CITY OF ALBUQUERQUE

October 16, 2019

Re: B&D Industries
9720 Bell Ave
Traffic Circulation Layout
Engineer's/Architect's Stamp 7-26-19 (L20D071)

### A1 SITE PLAN

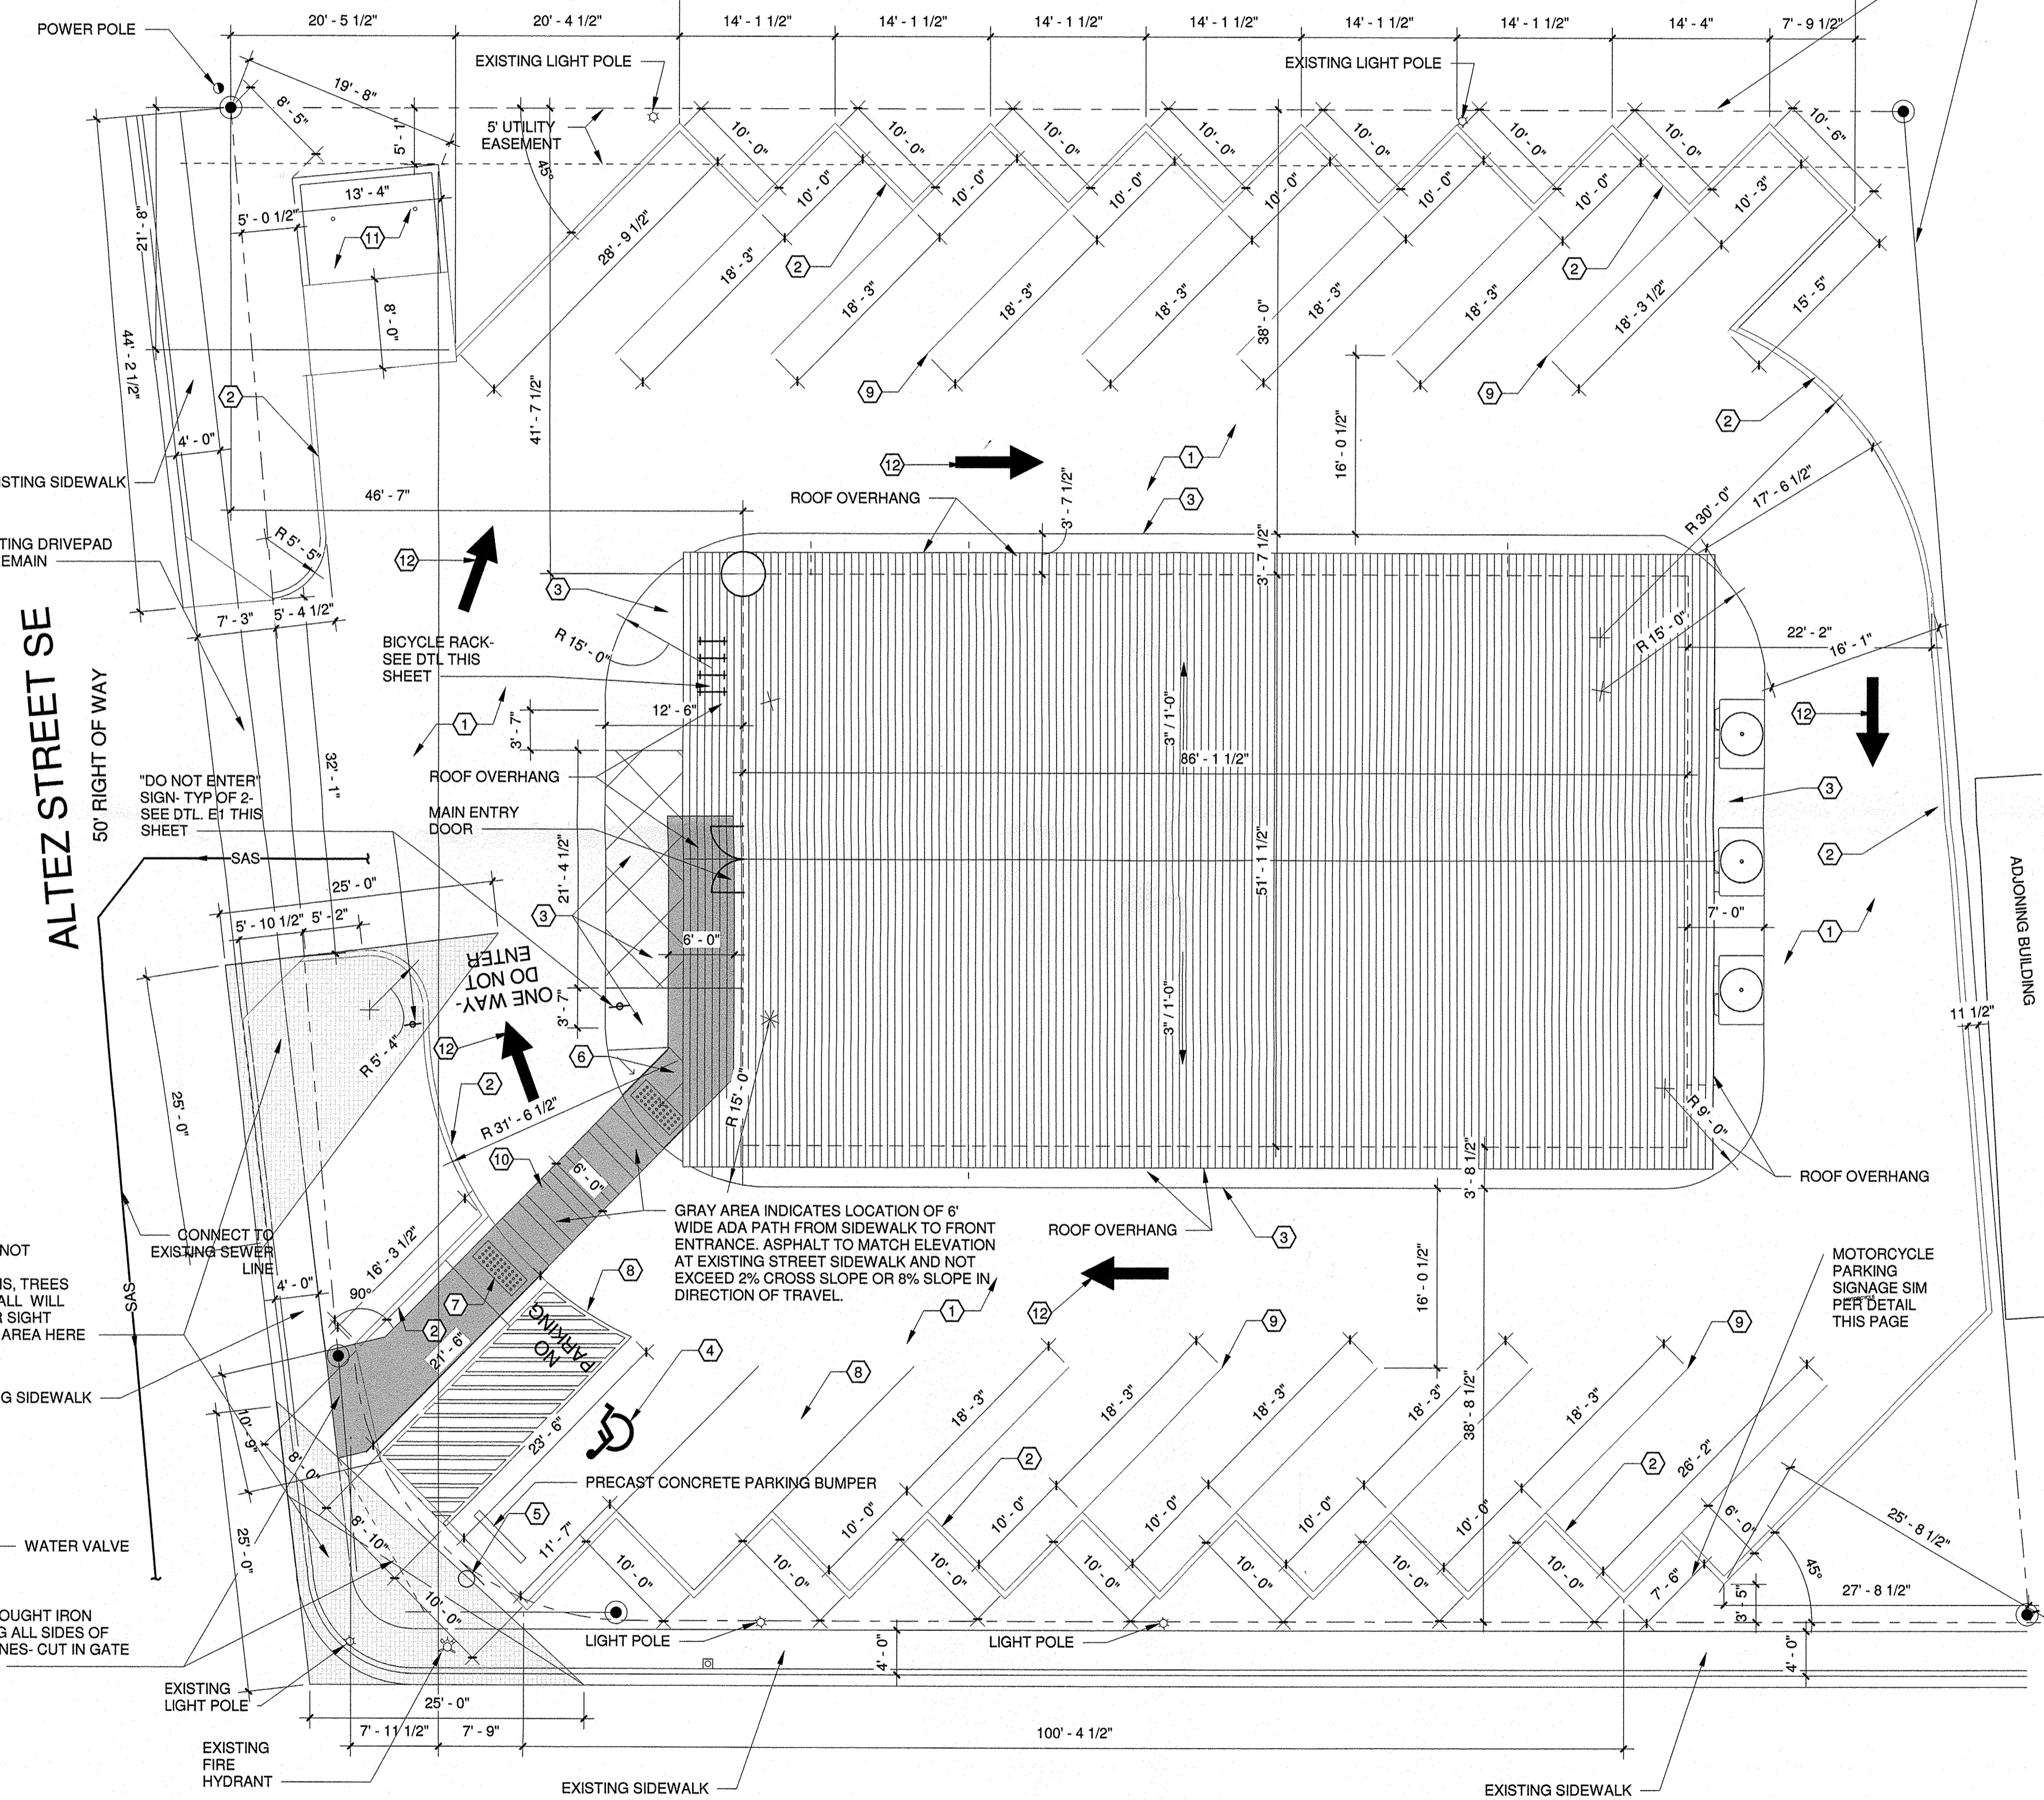
1. Please identify all existing sidewalks, curbs, drive pads, wall and anything that influences the parking and circulation on the site.
2. Identify all existing access easements and rights of way width dimensions.

3. Identify the right of way width.
4. Please add motorcycle & bicycle parking per IDO.
5. Show all drive aisle widths and radii. Some dimensions are not shown. (Indicate aisle widths at corners of concrete sidewalks around building to parking stalls.)

6. Per the IDO code, a 6 ft. wide ADA accessible pedestrian pathway is required from the public sidewalk to the building entrances. Please clearly show this pathway and provide details.

7. Service vehicle and/or refuse vehicle maneuvering must be contained on-site; provide a copy of refuse approval.
8. One-way vehicular paths require pavement directional signage and a posted **"Do Not Enter"** sign at the point of egress. Please show detail and location of posted signs.

11. Show the clear sight triangle and add the following note to the plan:
"Landscaping and signage will not interfere with clear sight requirements. Therefore, signs, walls, trees, and shrubbery between 3 and 8 feet tall (as measured from the gutter pan) will not be acceptable in the clear sight triangle."

12. Add a note stating "All broken or cracked sidewalk must be replaced with sidewalk and curb & gutter." A build note must be provided referring to the appropriate City Standard drawing.
